16th December 2019

Lindfield Learning Village - Stages 2 and 3 - Amended Scheme

Submission on behalf of Strata Plan 90970

# ATTACHMENT B

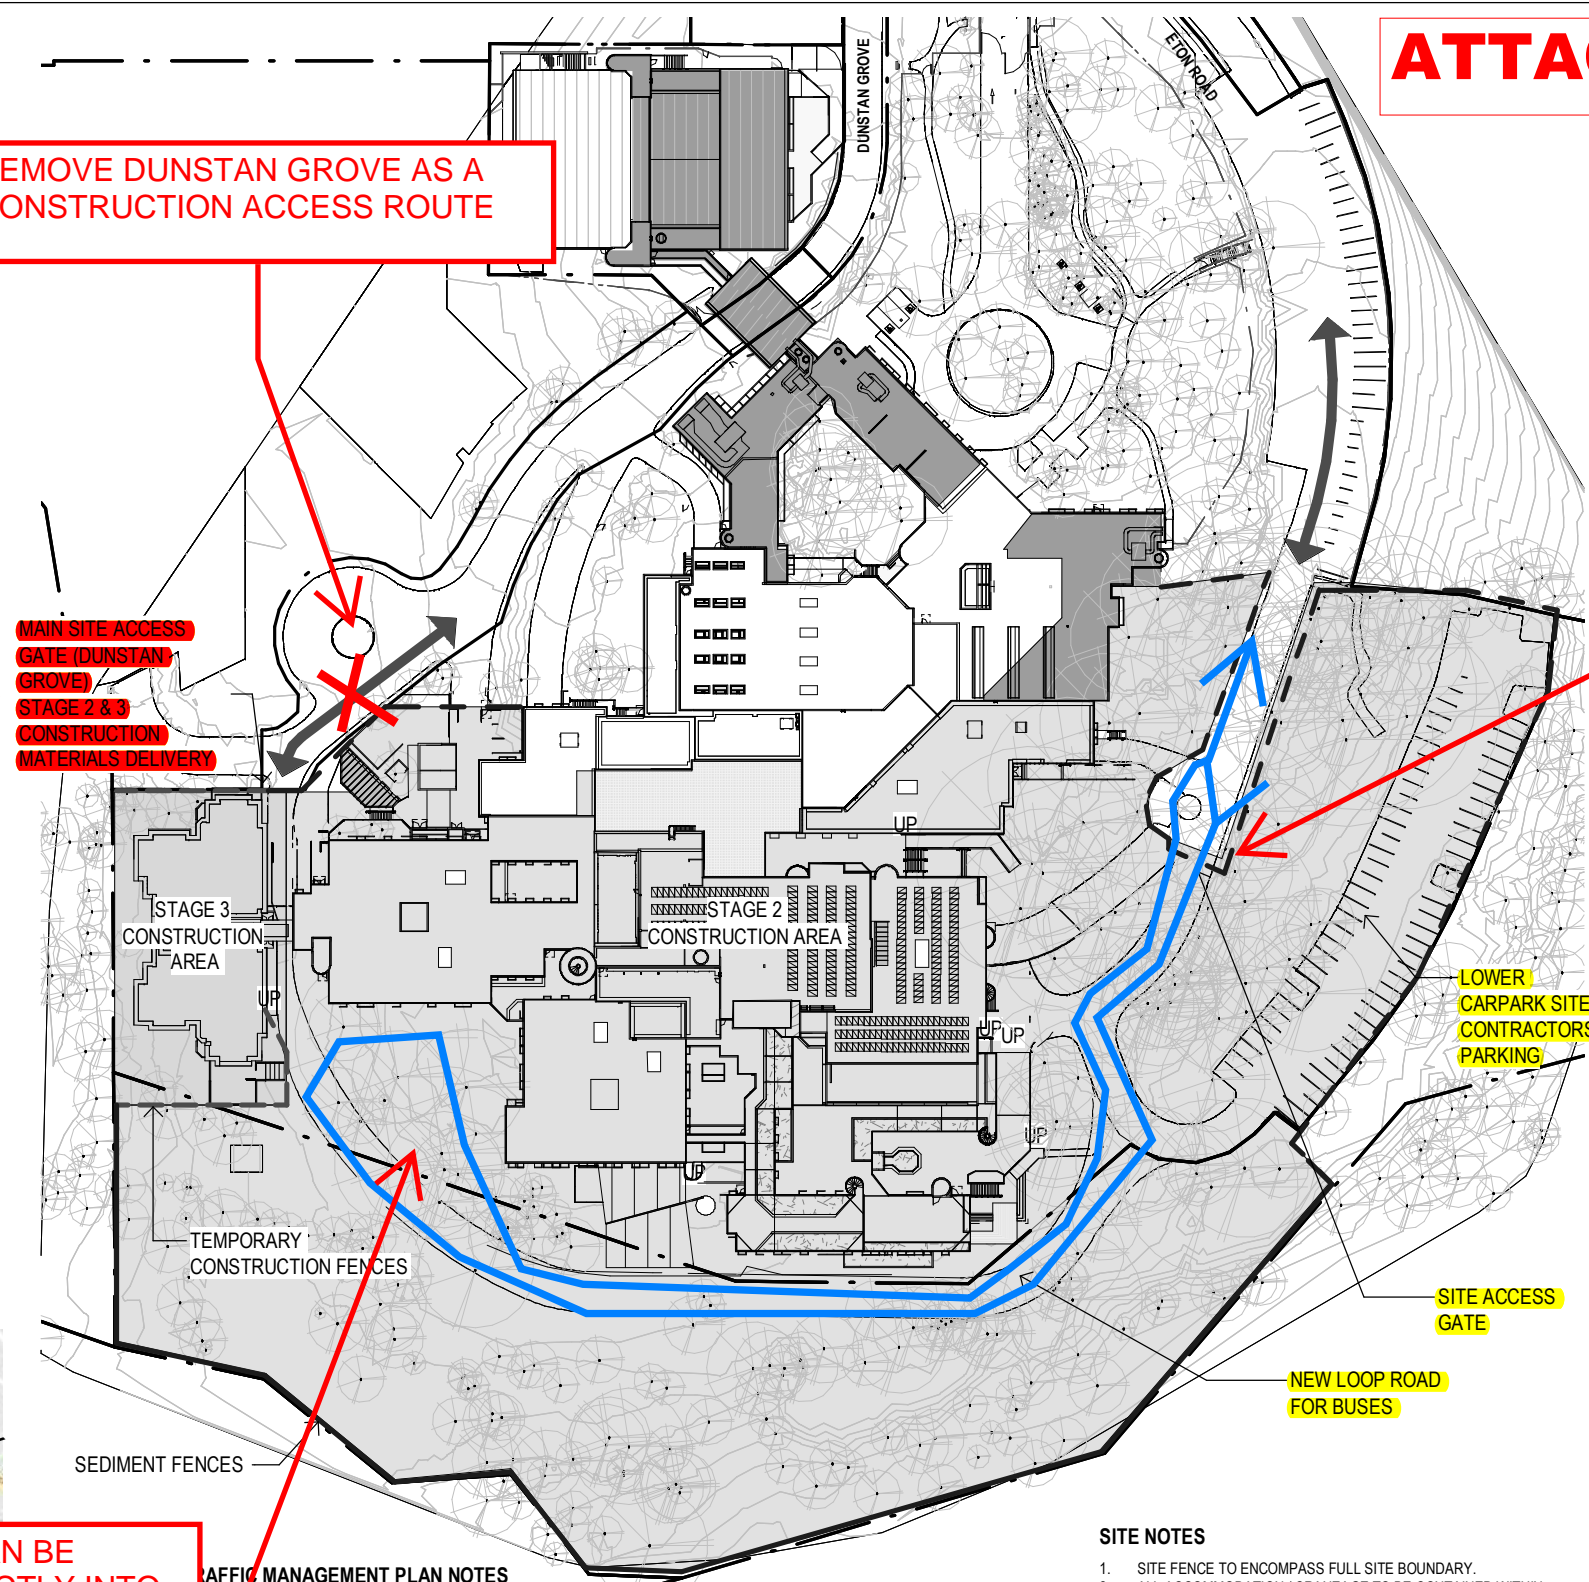
In the RTS documents, a new Construction Management Plan has been included (drawing no. DA-2-101-C) that shows the main site access gate again being at Dunstan Grove as per Stage 1. This is contrary to the discussion at the consultation meetings and is completely inappropriate (being within 20m of residential apartments), when superior alternatives have been identified which mitigate this impact.

During the two consultation meetings it was demonstrated to Schools Infrastructure that a better point of access is at the eastern point of connection of the Loop Road. Entry gates can be established here, and vehicles can drive straight from Eton Road into the site compound. This can all be managed by traffic control within the school boundaries to mitigate any impacts on school students / staff. They will then be able to turn in the compound and exit driving forward. Refer to the marked up Construction Management Plan attached at the end of this letter (Attachment B).

It is completely inappropriate for the Main Construction Access to be off Dunstan Grove, and at the (only) Main Entry of our residences for the two-year construction period.
